**Rezoning Transportation Analysis**  
**Petition Number: Insert Zoning Petition #2020-190**  
*General Location Identifier: Tax ID 12522705*

Revision Log:	Date	Description
	01-21-21	First Review (WB)
	02-15-21	Second Review (WB)
	03-09-21	Third Review (WB)
	03-24-21	Fourth Review (WB)

SHEET NUMBER: **RZ-1**

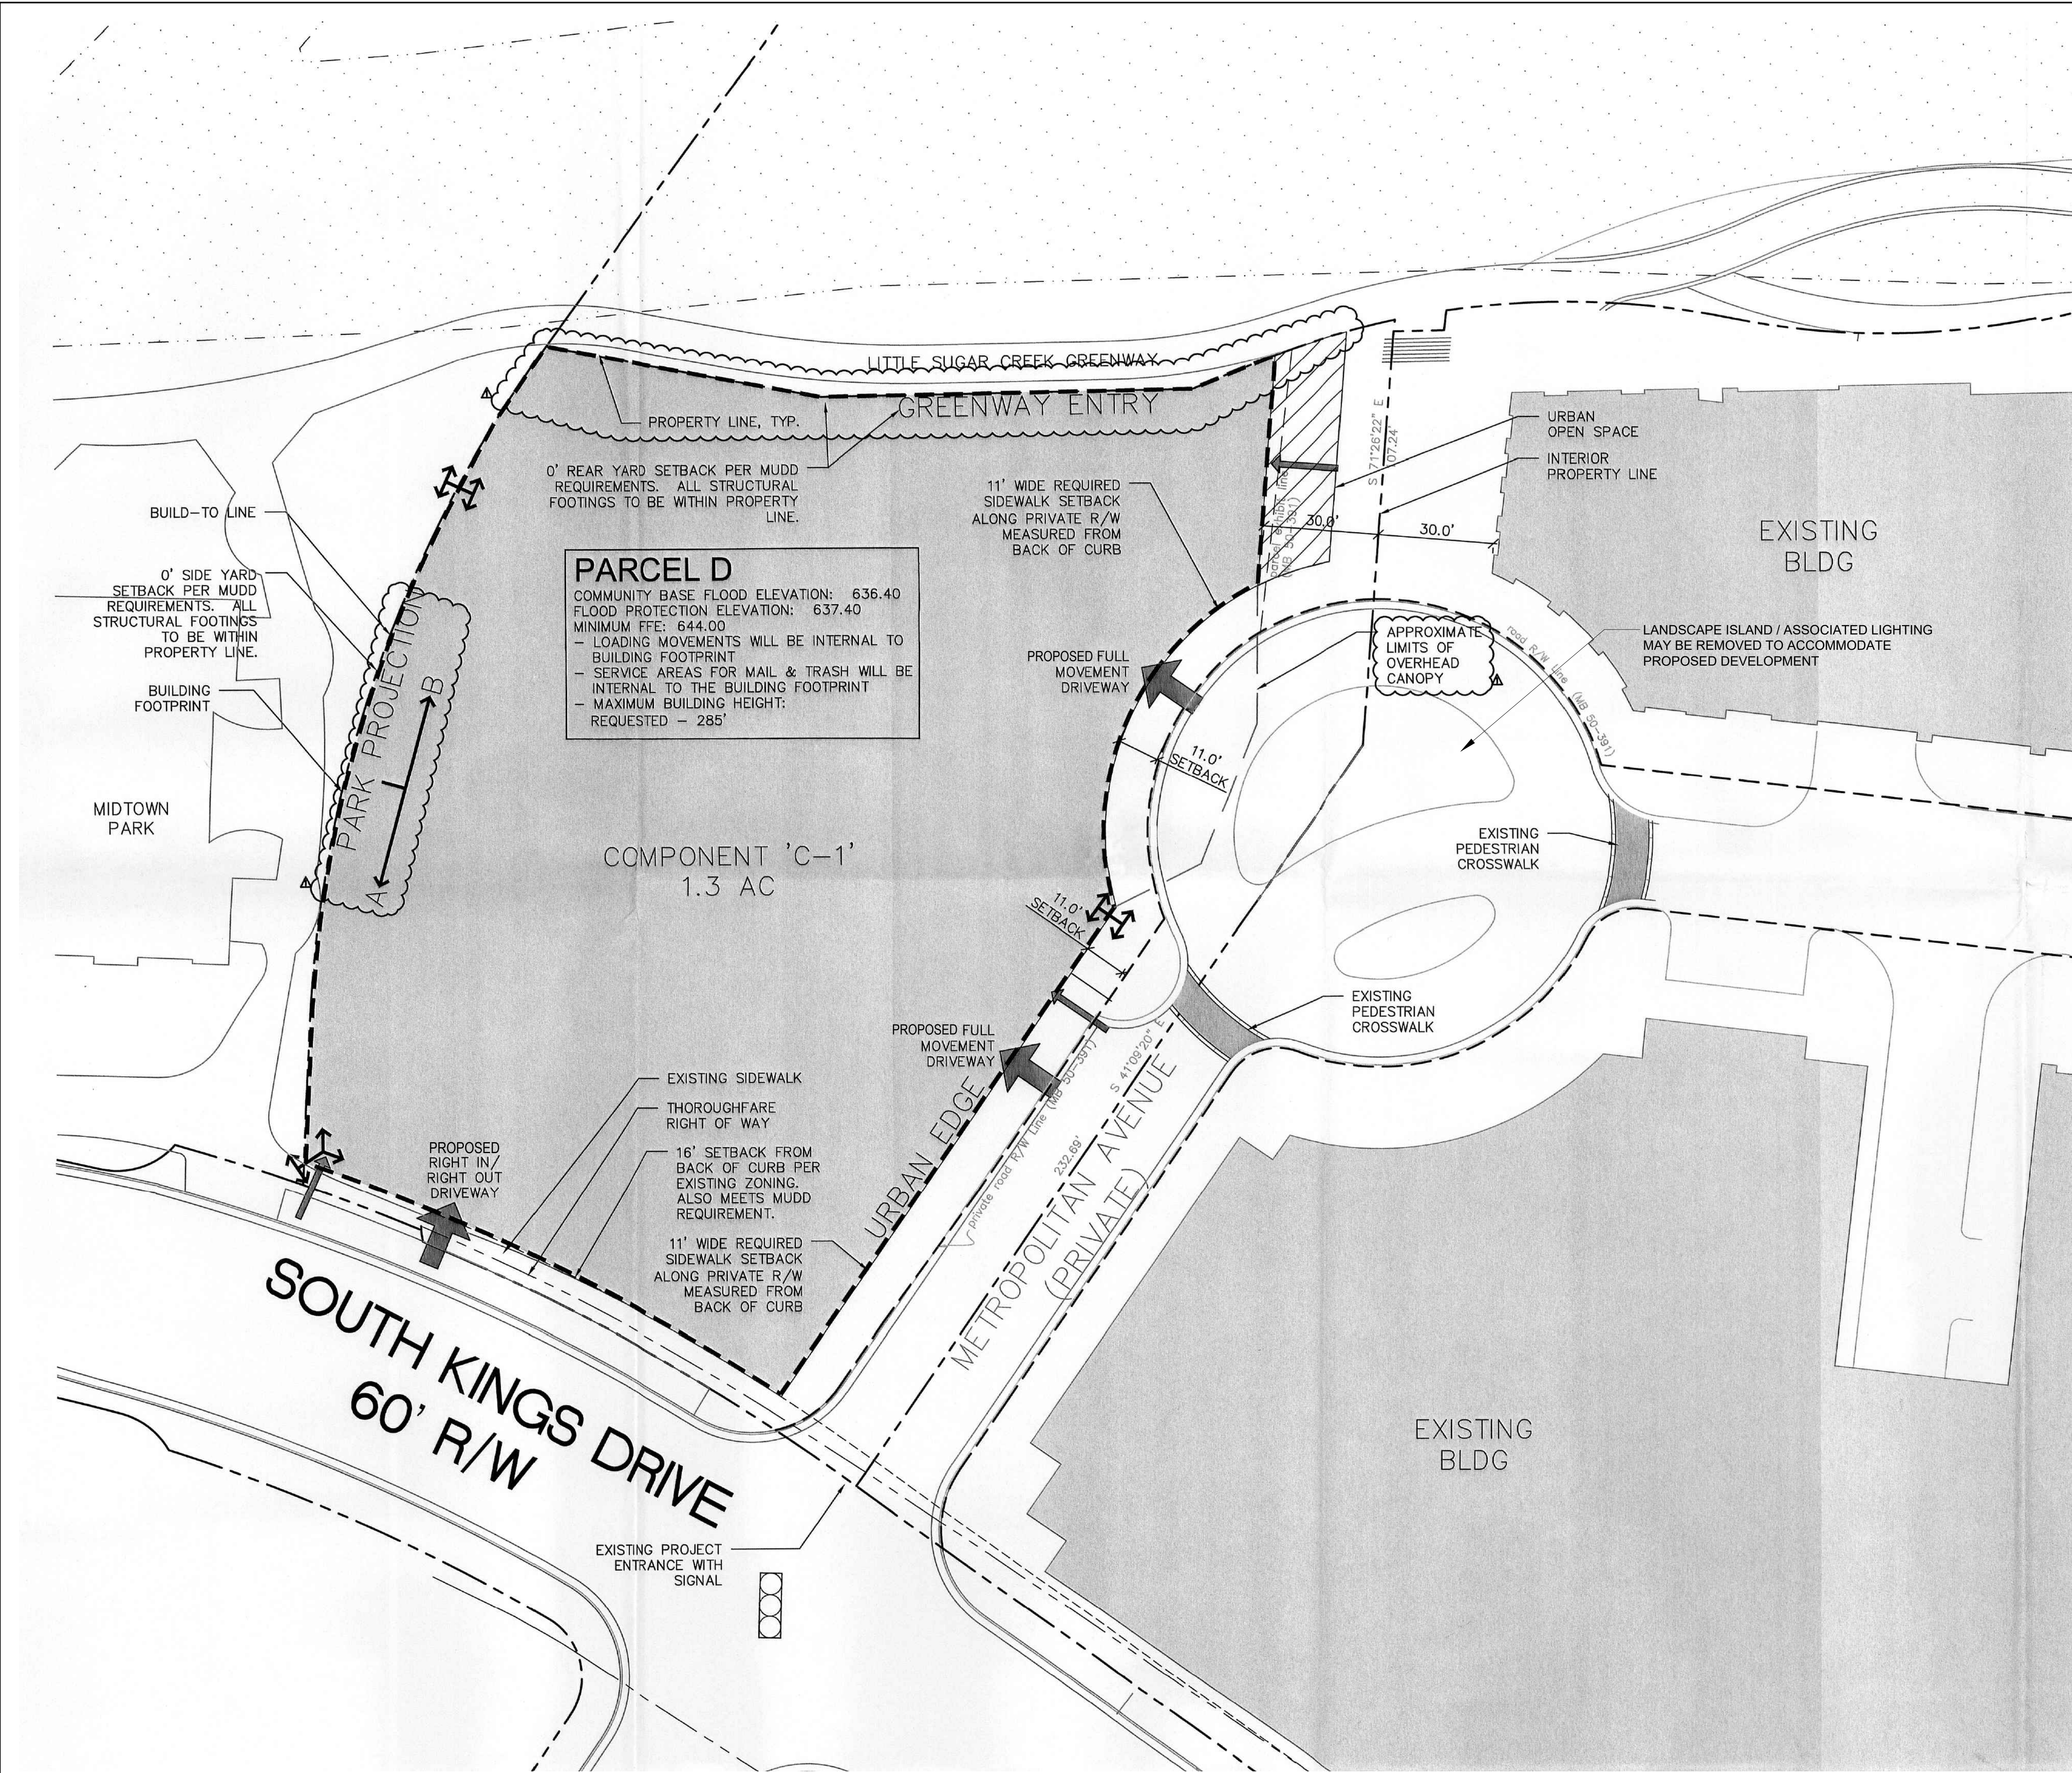
~~Label and dimension the curb and gutter from the centerline for each road on the site plan.~~

3. ~~Revise site plan and conditional note(s) to commit to dedicate 40' right-of-way from the South Kings Drive centerline. The site plan shall label and dimension the right-of-way from the road centerline.~~

~~Comment Revised (based on a meeting held on 2/22/21, wherein the access point of concern was identified by the petitioner as a service only drive; hence, alleviating traffic and signal-related concerns). Revise site plan and conditional notes to commit to constructing a Service Only driveway. Label the south-most driveway on Metropolitan Avenue as a Service Only driveway. Resolved (3/24/2021)~~
